AQUIND INTERCONNECTOR

Consultation Report – Appendix 1.7G Marine
Specific – Briefing Note for Ongoing
Consultation with Historic England August
2019

Document Ref: 5.1.7G

Briefing Note to inform Ongoing Consultation: Responses to PEIR feedback

TITLE:
Figure 14.1 Location of Aquind Interconnector Marine Cable Corridor (UK Sector)

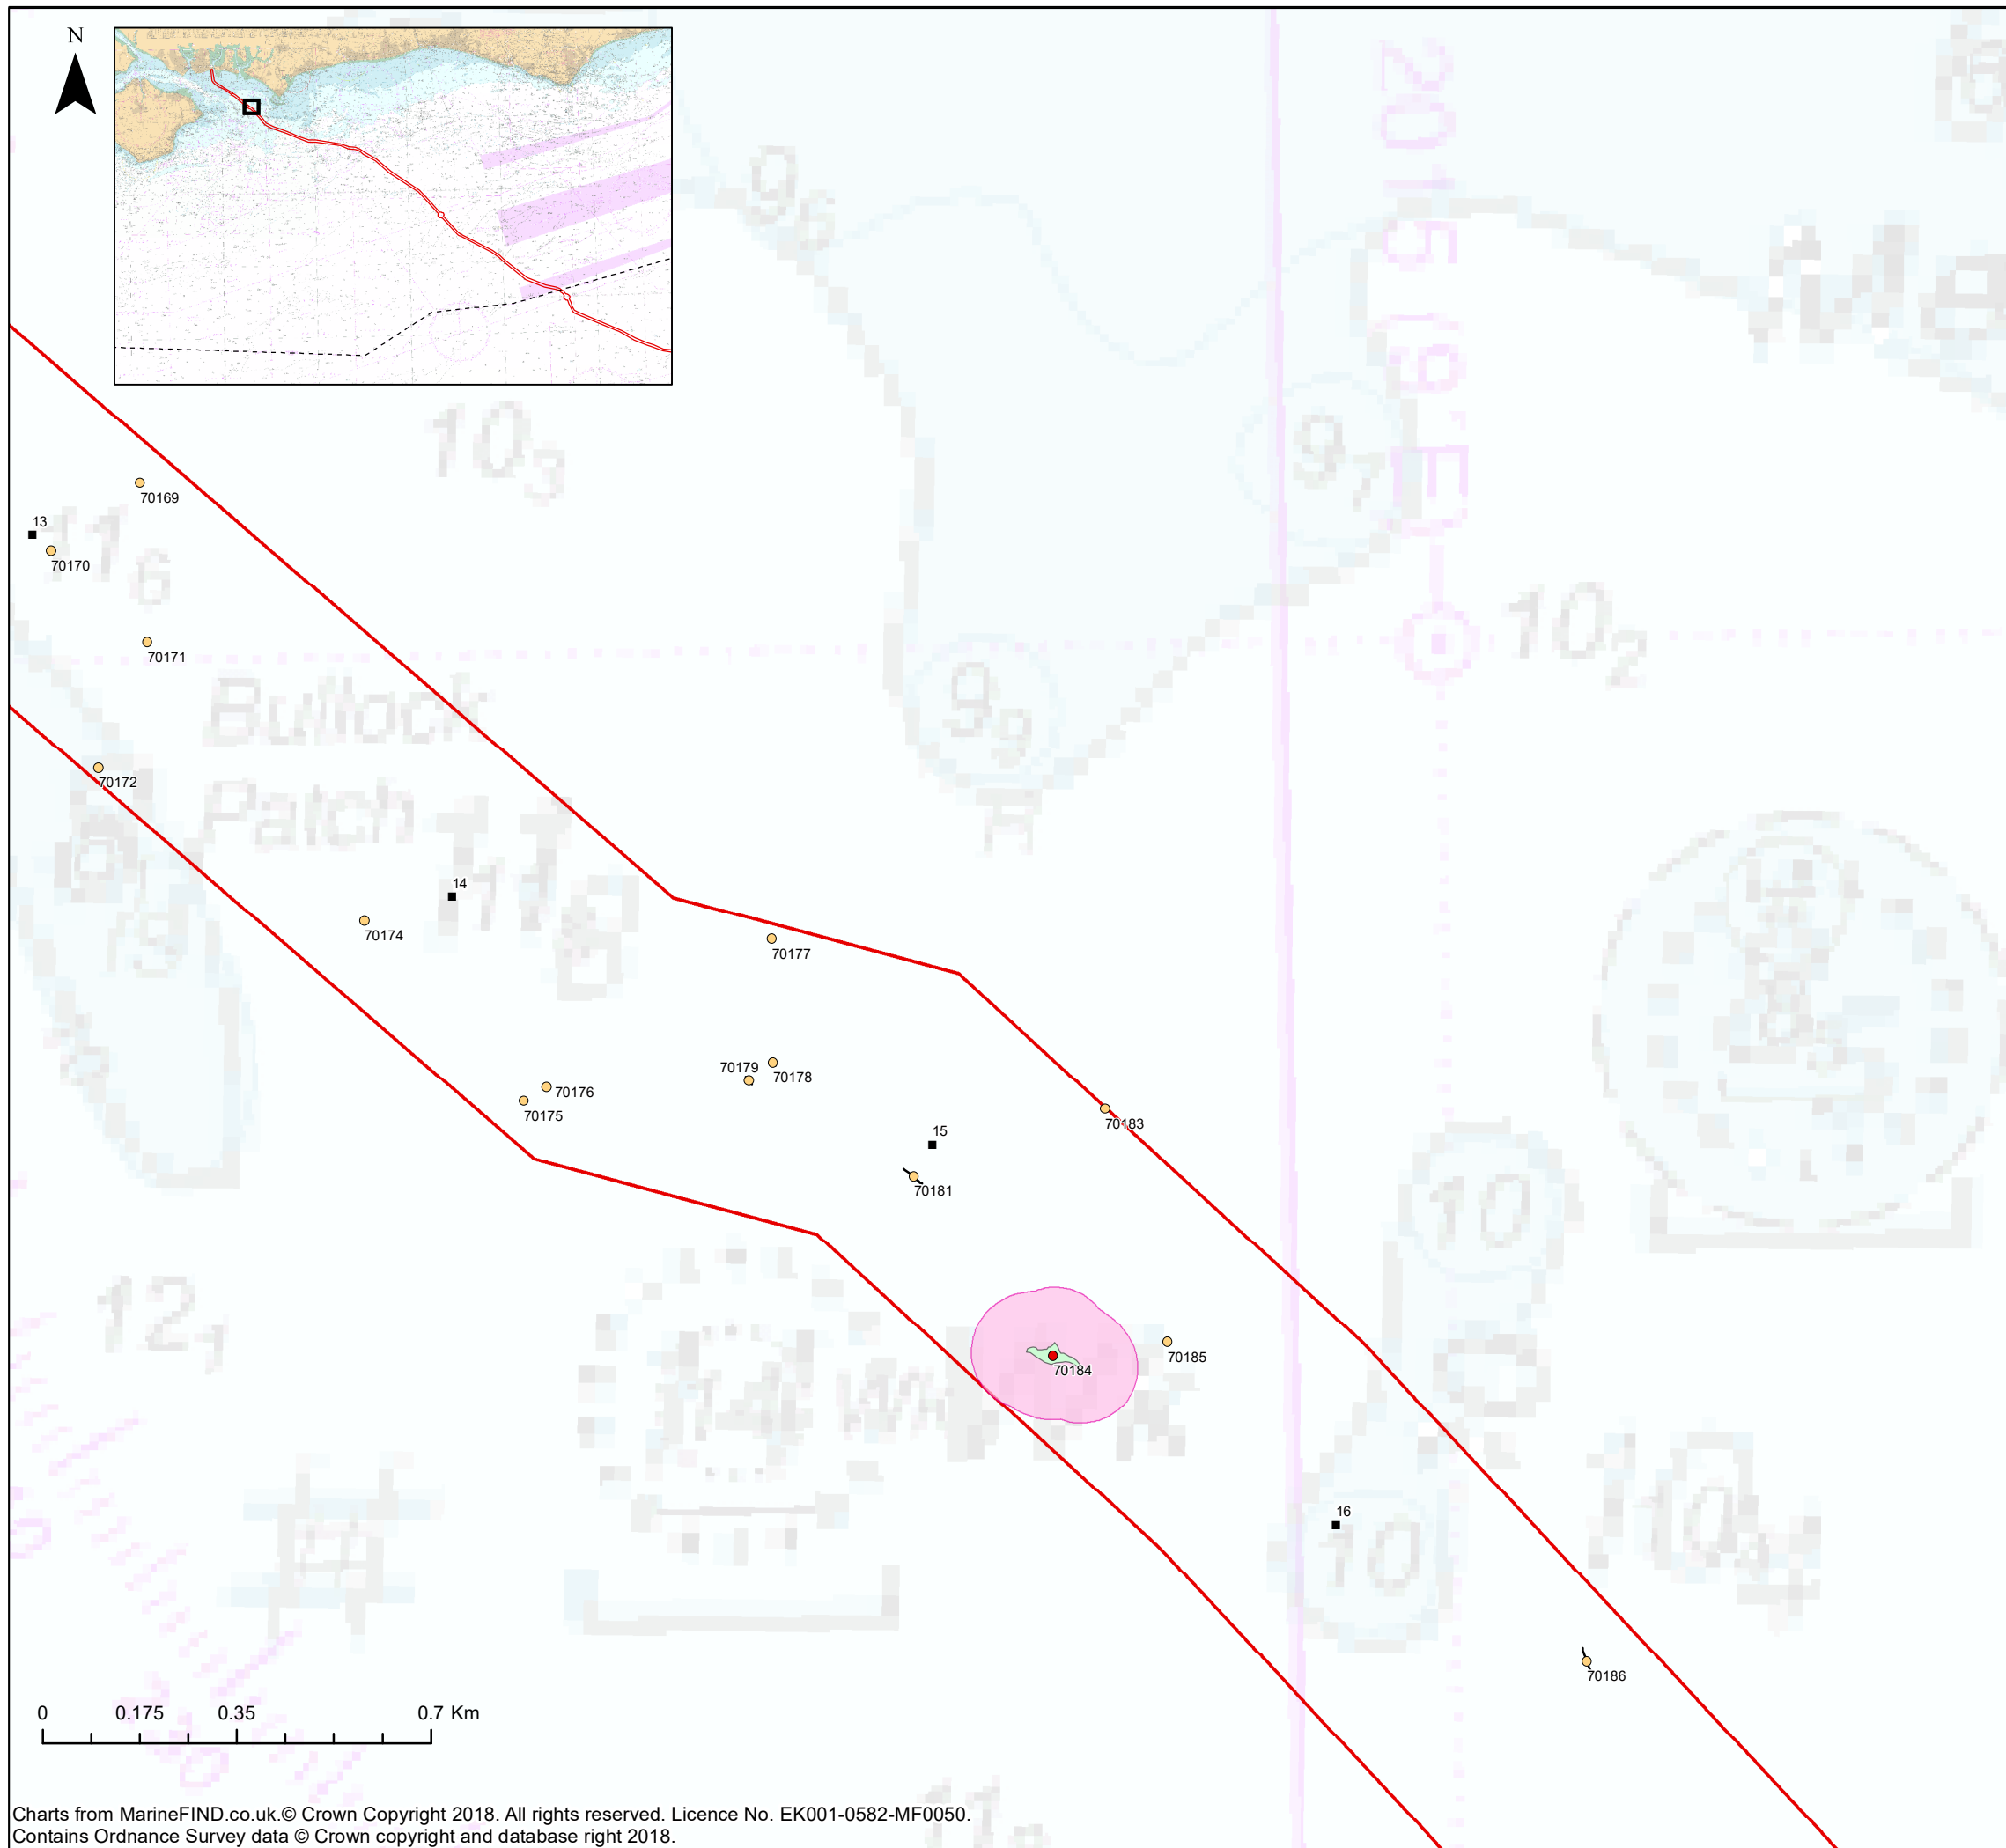
Item No.	Topic	Comment	Applicant's Response
			the project description. Any potential significant environmental effects will be assessed accordingly within the final ES.
9	Marine Archaeology	Sub-section 14.2.2 'Legislation' of Chapter 14 states that there are no Scheduled Monuments within the Proposed Development or ASA. This must be clarified to distinguish this comment as relating to below MHWS as the map of the ASA in Figure 14.1(same Chapter) clearly shows that the ASA buffers extends over not only Fort Cumberland (a scheduled monument) but also over a significant proportion of Portsmouth, Southsea and Langstone Harbour where further designations are present.	<p>Figure 14-1 shows the data collection search area (ASA), but the presented gazetteer is then restricted to the Marine Cable Corridor. So yes, the data collection buffer extends onshore, but only marine and intertidal elements are taken forward in this chapter. Onshore receptors - such as Fort Cumberland - are discussed within the relevant onshore chapter.</p> <p>Figure 14.1 will be updated to make this clearer.</p>
